Representing the community's interests in getting around on bikes in Sydney's eastern suburbs

UNSW Health Translation Hub Application SSD-10822510

14 June 2021

Ground 00

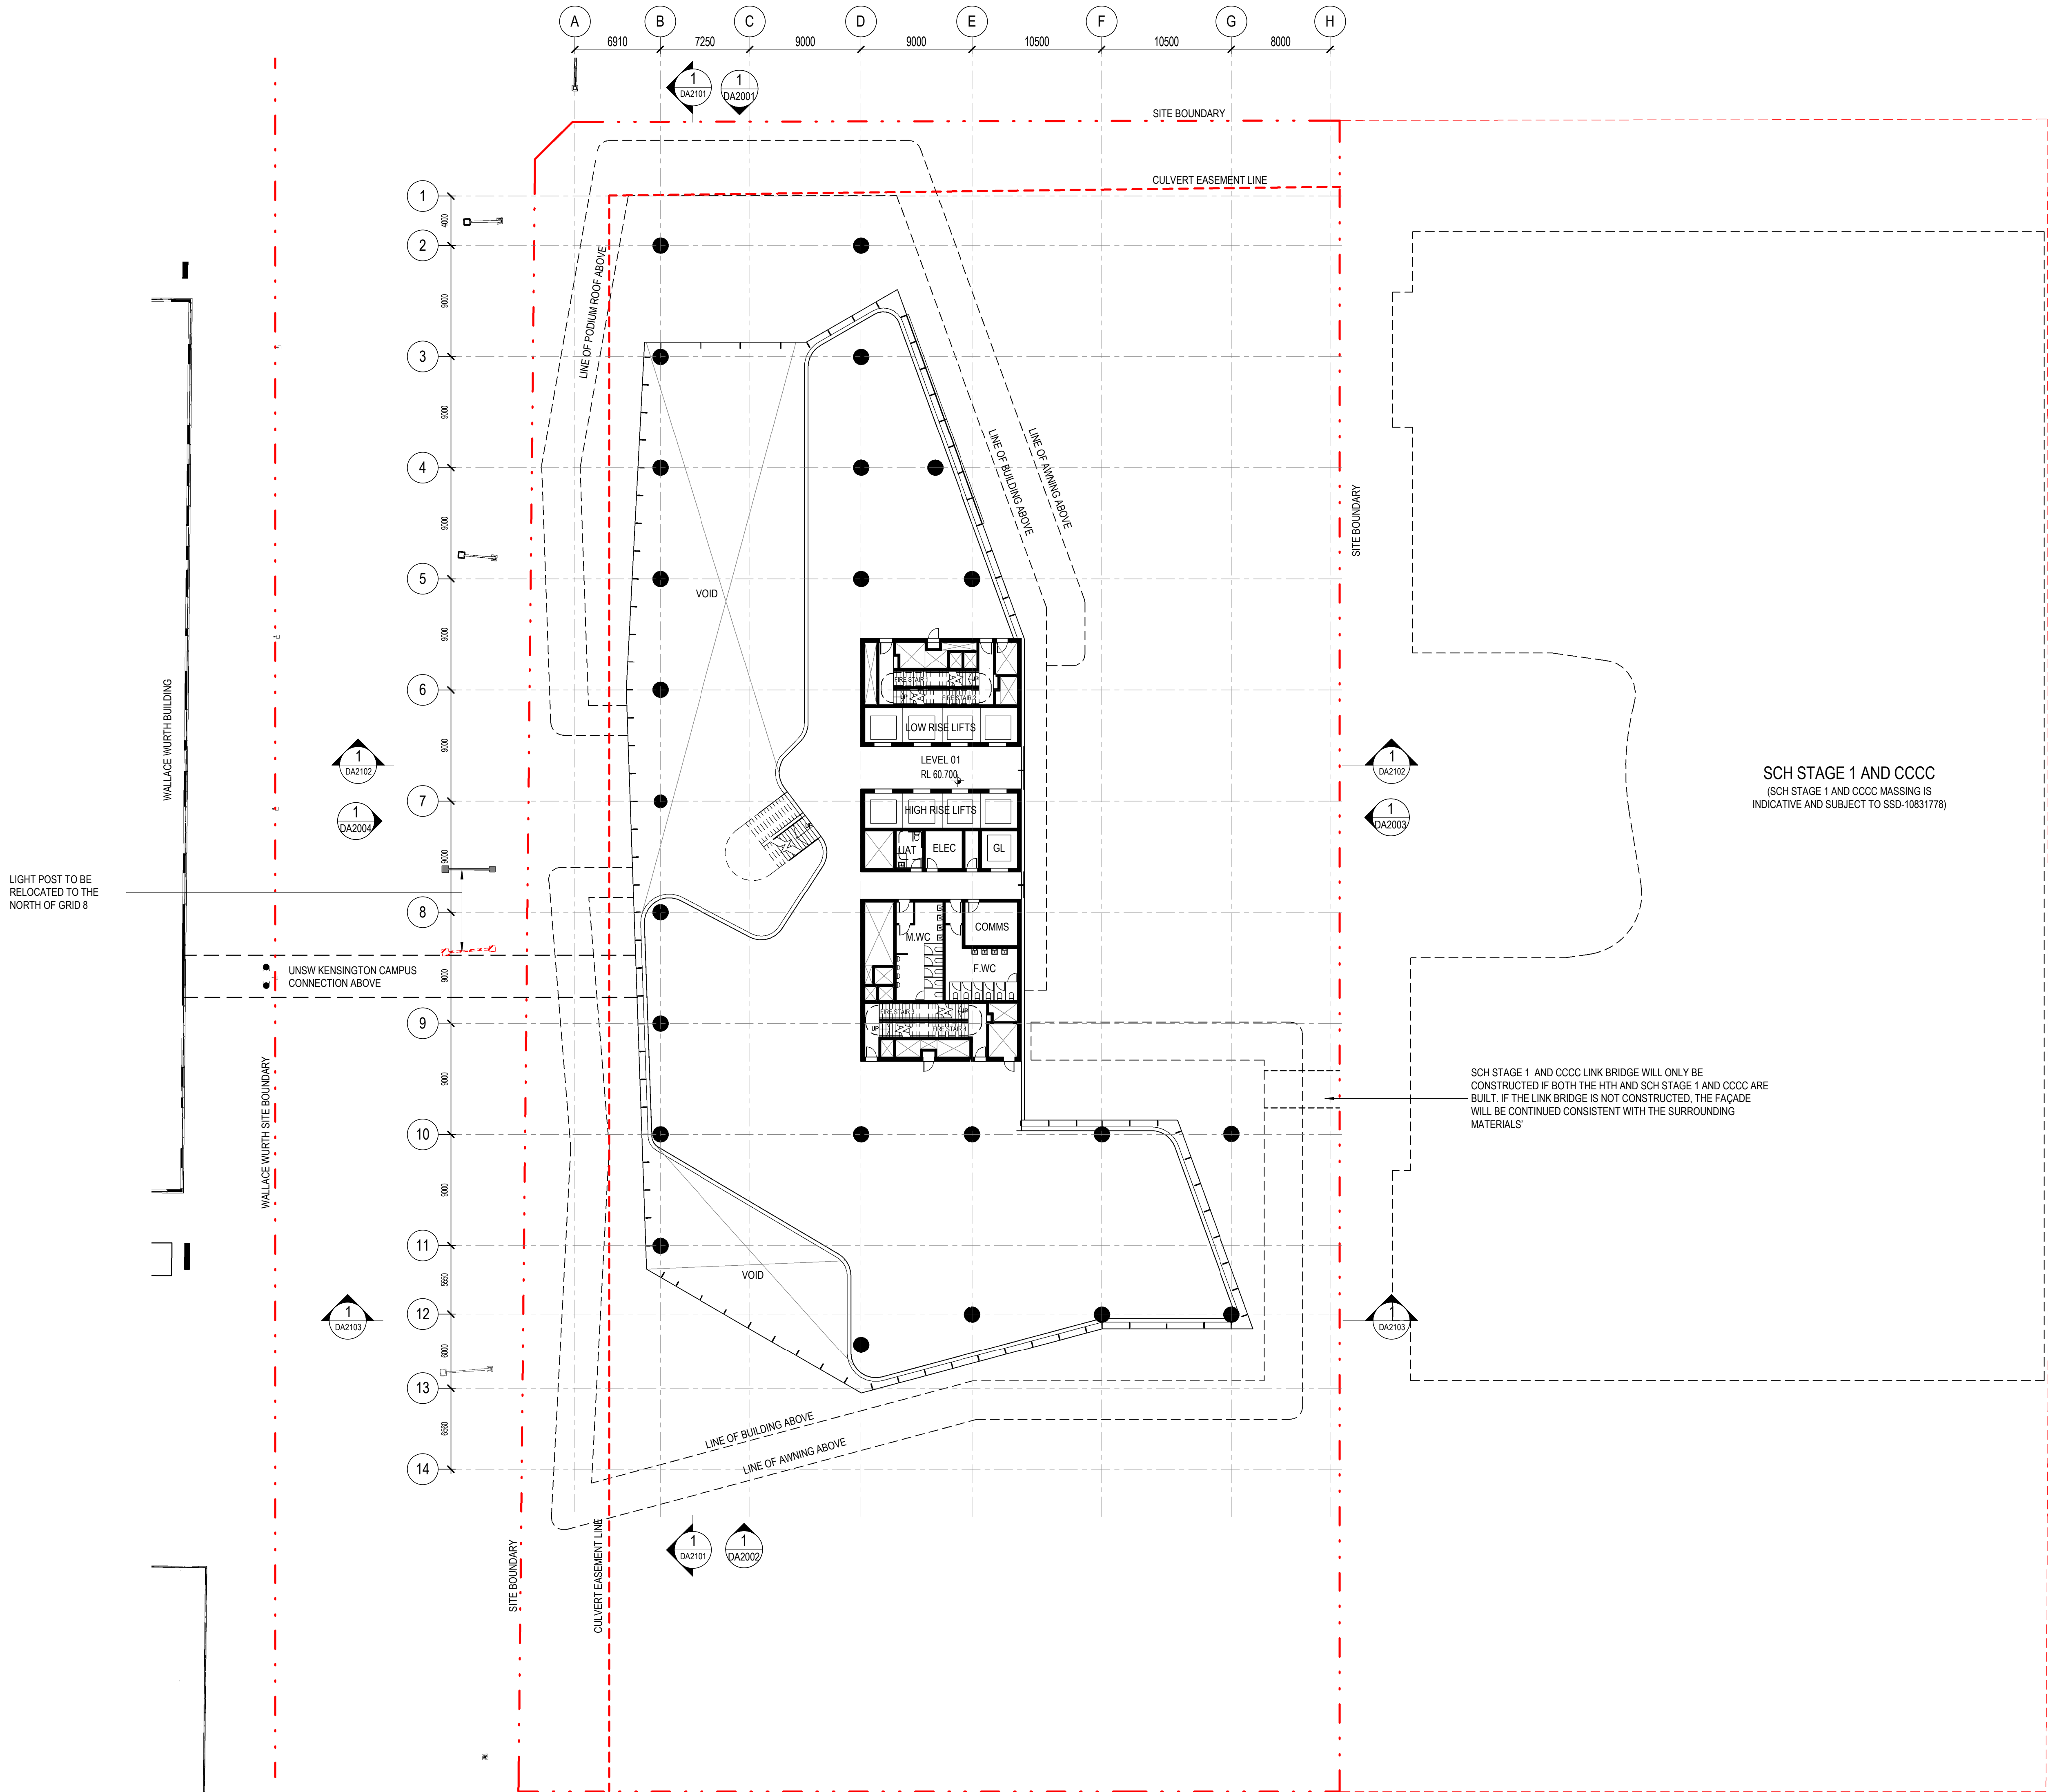
- We also encourage the design team to **ensure safe and comfortable cargo bicycle access** through the End of Trip entry door near gridline 12, and the internal and external ramps on either side of this entry door. We are concerned that the maneuvering clearances through the 90-degree turns and around the door swings seem narrow for pushing a cargo bike.

- We are concerned that the **short term bicycle parking racks shown near grid A5 are located in a relatively distant and unmonitored location**, and will be underused for these reasons. We would encourage the design team to reconsider this location. A position nearer a building entry or within the UNSW Plaza would be better used and better protected.
